Ribble Valley Borough Council  
Council Offices  
Church Walk,  
Clitheroe  
Lancashire  
BB7 2RA

Phone: 0300 123 6780  
Email: [developeras@lancashire.gov.uk](mailto:developeras@lancashire.gov.uk)  
Your ref: 3/2026/0434  
Our ref: 3/2026/0434/HDC/KW  
Date: 01 July 2026

**Location:** Higher College Farm Lower Road Longridge PR3 2YY  
**Proposal:** Variation of conditions 2 (approved plans) and 6 (parking provision) to increase the roof height of the approved garage, provide an external staircase and include 7 no. rooflights to facilitate first floor office space on planning permission 3/2025/0614 for change of use of the existing dwellinghouse (C3) to a small children's residential home (C2).  
**Grid Ref:** 361561 437175

Lancashire County Council acting as the Local Highway Authority (LHA) does not raise an objection regarding the variation of conditions 2 (approved plans) and 6 (parking provision) on planning permission 3/2025/0614.

DRG NO.  
EAD\_314\_P\_03

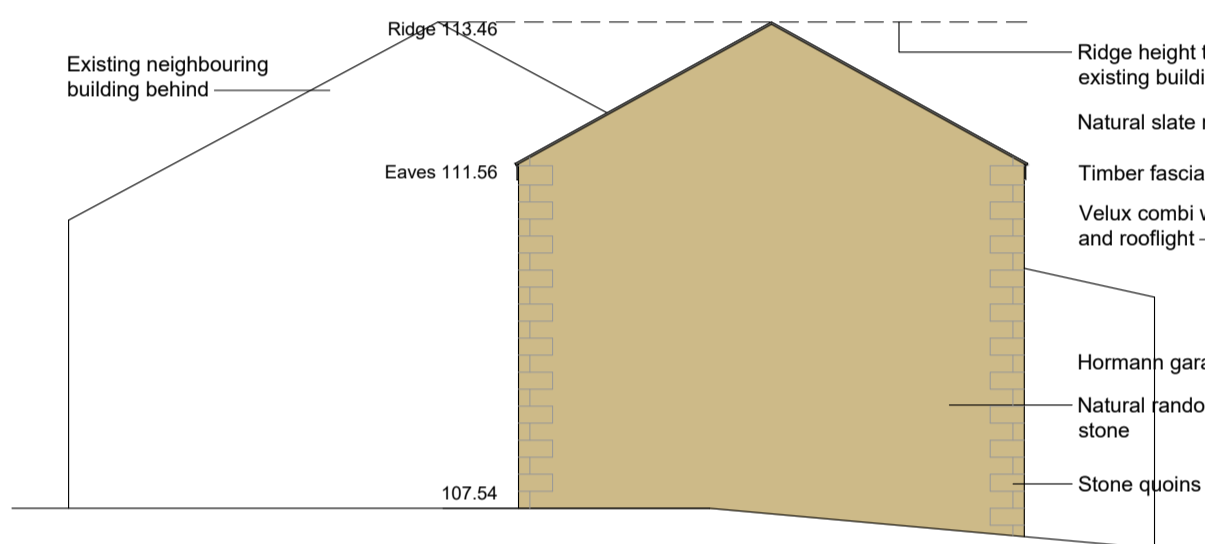
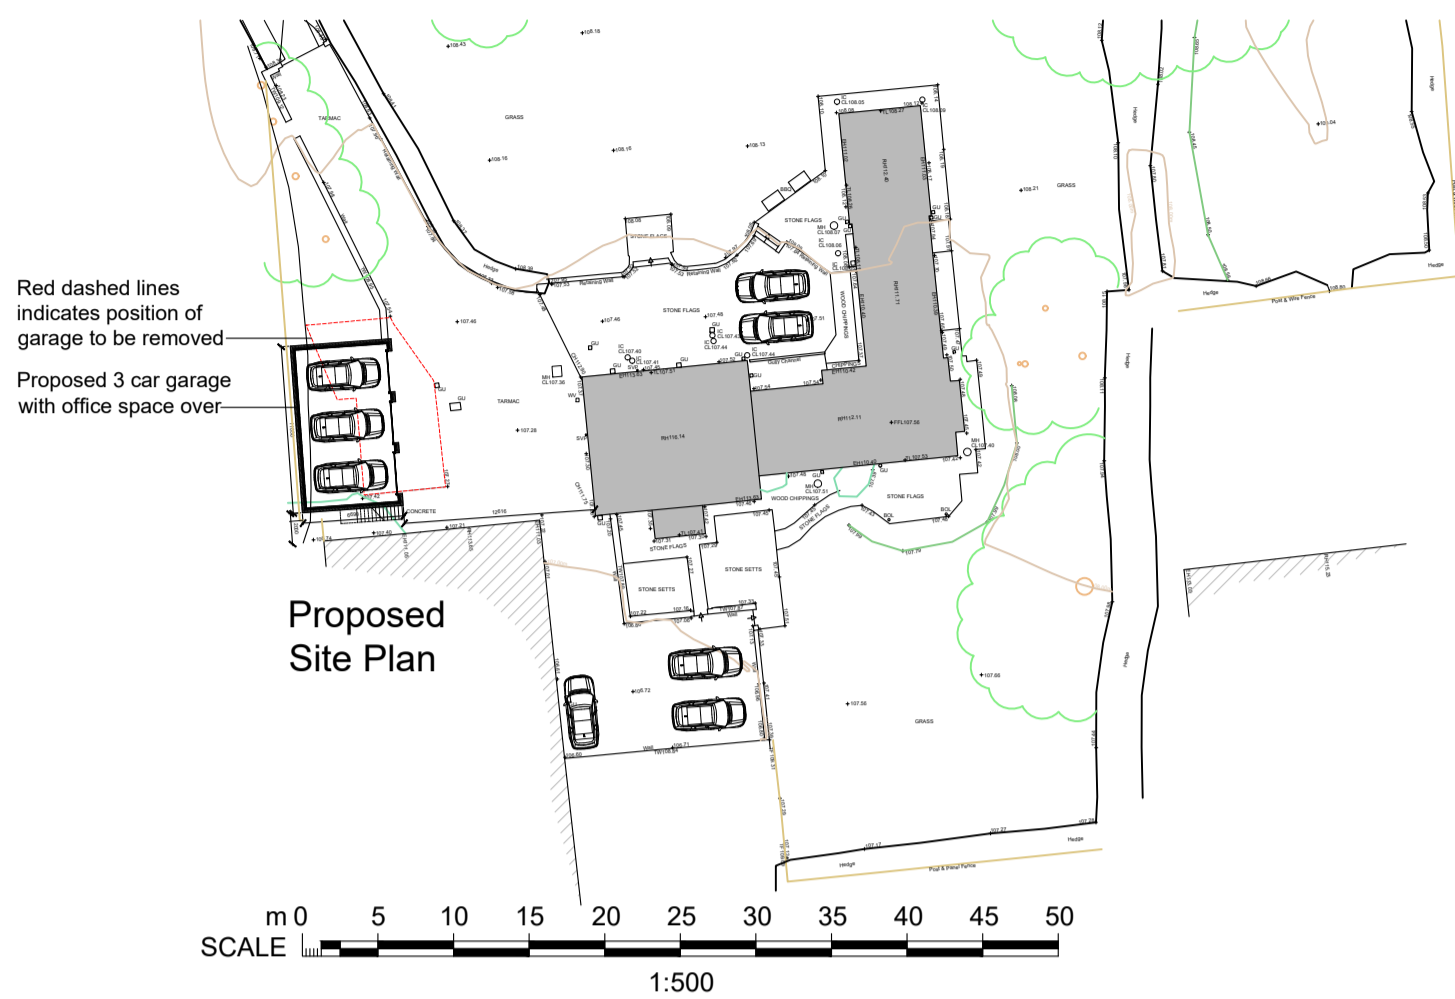
The LHA has no objection to the variation of conditions 2 and 6 on planning permission 3/2025/0614. The LHA has reviewed drawing EAD\_314\_P\_03 and notes that the parking is at the same provision level as the approved scheme under application 3/2025/0614. The proposed garage meets the recommended minimum internal dimensions for a garage which can support 3 car parking spaces. It is noted that the proposed office space is for the provision of a dedicated area for staff to undertake administrative tasks in a space which is separated from the main living accommodation, and as such will not change the use which has been approved under application 3/2025/0614.
